Statement of Common Ground with Wiltshire Bridleways Association (Tracked)

Revision ~~2~~3

Planning Inspectorate Reference: EN010168

Document Reference: EXAM/8.17

LIME DOWN SOLAR PARK
Figure 3-4-2
Lime Down Solar Park - Site B
Landscape and Ecology Mitigation Plan - Revision 3
EN010168/APP/6.2
5(2)(a)

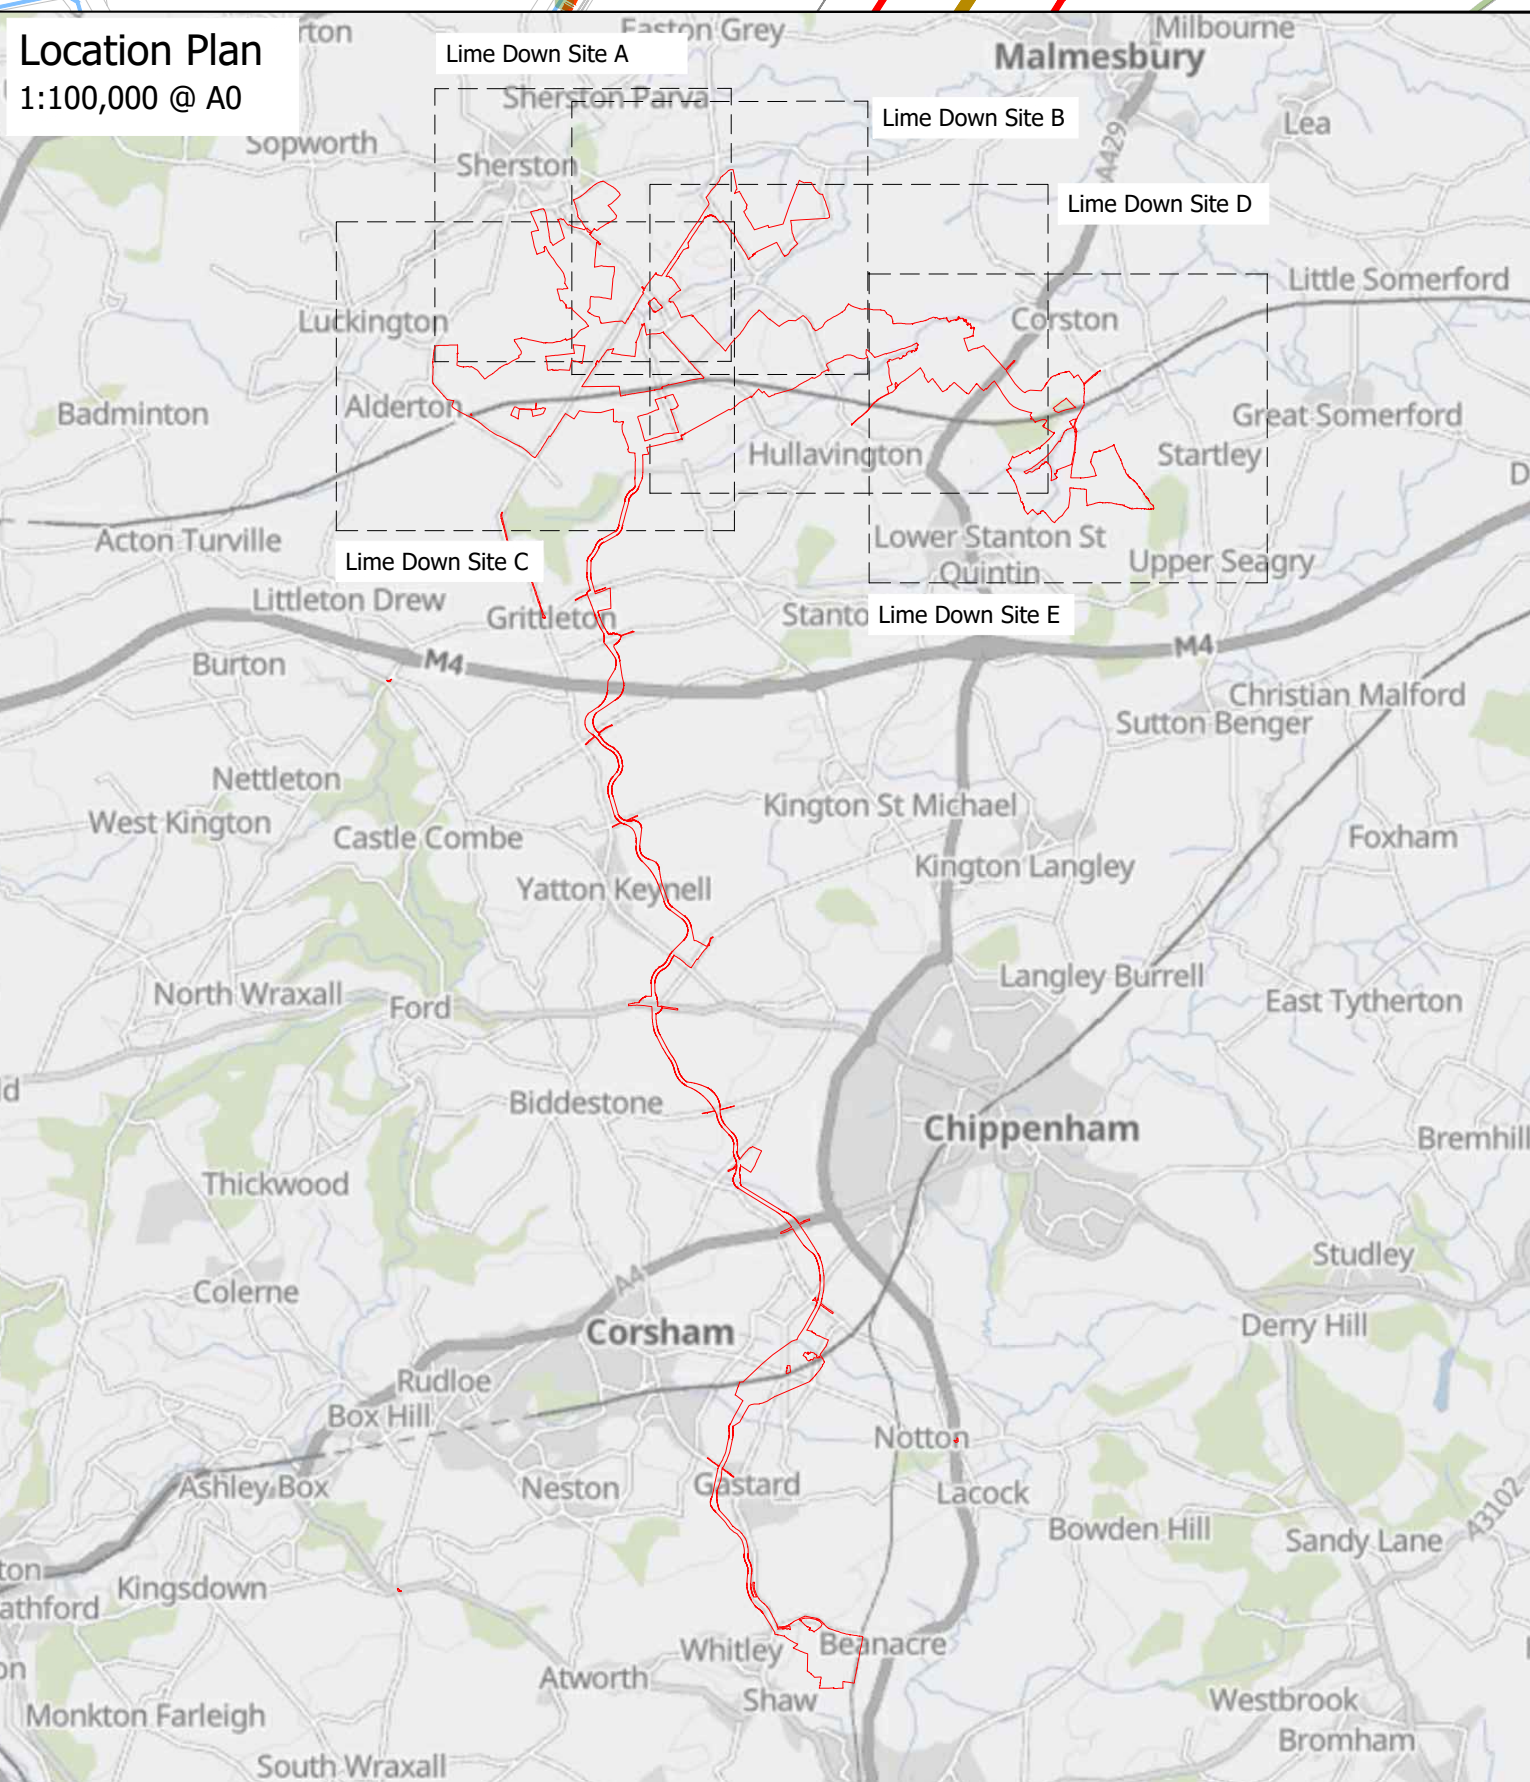
3.1.11	Mitigation - Fencing	The WBA would like the minimum path width to follow British Horse Society guidance at 3 metres and for fencing to be of vegetation rather than corrugated metal which would make the paths feel narrower. Updated position	A minimum surface width of 3 m is proposed for bridleways, as recommended by guidance from the British Horse Society. However, only groundcover planting will be planted immediately alongside PROWs, allowing users to pass at a greater width if required. Where new	Under DiscussionAgreed

Reference	Sub-topic	WBA Position	Applicant's Position	Status
		<u>WBA accepts that a 3m width for bridleways is inline with BHS recommendations and will be sufficient.</u>	hedgerow planting is proposed alongside PROWs, this will be planted to maintain a suitable passable width that is to be determined at the detailed design stage. This is shown indicatively on ES Volume 2, Figures 3-4-1 to 3-4 5.2: Landscape and Ecology Mitigation Plan [REP-029 to REP1-032]. The majority of site fencing is to consist of 2 m deer stock fencing (i.e. wooden posts with wire mesh) set a minimum of 15 m from the centreline of the nearest PROW. Metal palisade fencing is only proposed in locations where there is a danger to life, and so is limited to substation and BESS enclosures. Palisade fencing is not proposed adjacent to PROWs. These principles (including offsets to PROWs, PROW widths, and fencing and PV types), are set out in the Design Principles and Parameters [REP1A-008] and indicatively shown on the ES Volume 2, Figures 3-4-1 to 3-4

Reference	Sub-topic	WBA Position	Applicant's Position	Status
		WBA are also disappointed that the permitted path through Lime Down B is to be for pedestrians only, WBA understand that this is due to current incidences of anti social behaviour involving motorbikes but would like the Applicant to find ways of allowing bicycle and equestrian use of this path.	permissive bridle routes in Lime Down A between SHER14/Foxley-Sherston Road and two points on SHER16, both a permissive path and permissive bridle route in Lime Down E connecting MALW59 to MALW61, and to MALW63 (SSTQ4) respectively, and permissive bridle routes connecting SHER35 to the Fosse Way and connecting LUCK57 at Cream Gorse to the public highway near Alderton Church through Lime Down C. The Applicant confirms that as SEAG23/GSOM9 fall outside the Order Limits and within the land of a separate landowner, means of connecting this route to MALW61 have not been able to be explored further. The Applicant has however committed to allowing space for future network improvements (such as potentially between Seagry Wood and Rodbourne Bottom) to come forward at a later date,

Reference	Sub-topic	WBA Position	Applicant's Position	Status
			The Applicant currently can only <u>able to</u> commit to a permissive path for pedestrians on Lime Down B. <u>This is</u> due to the route intersecting a public footpath (NORT10), however will continue to explore increased accessibility <u>and to previous instances of anti-social behaviour both on the Site at Lime Down B and nearby land under the same ownership. This involved trespassing by motorcyclists and 4x4 drivers. As a result, police and political involvement was required to stop reoccurrences. On this basis, provision of additional access onto this permissive route with the relevant landowner(s) for cyclists and equestrians has not been able to be agreed.</u> The Applicant has worked with Wiltshire Council's PRow and Countryside Access Team to generate permissive path links and explore means by which PRow infrastructure within the
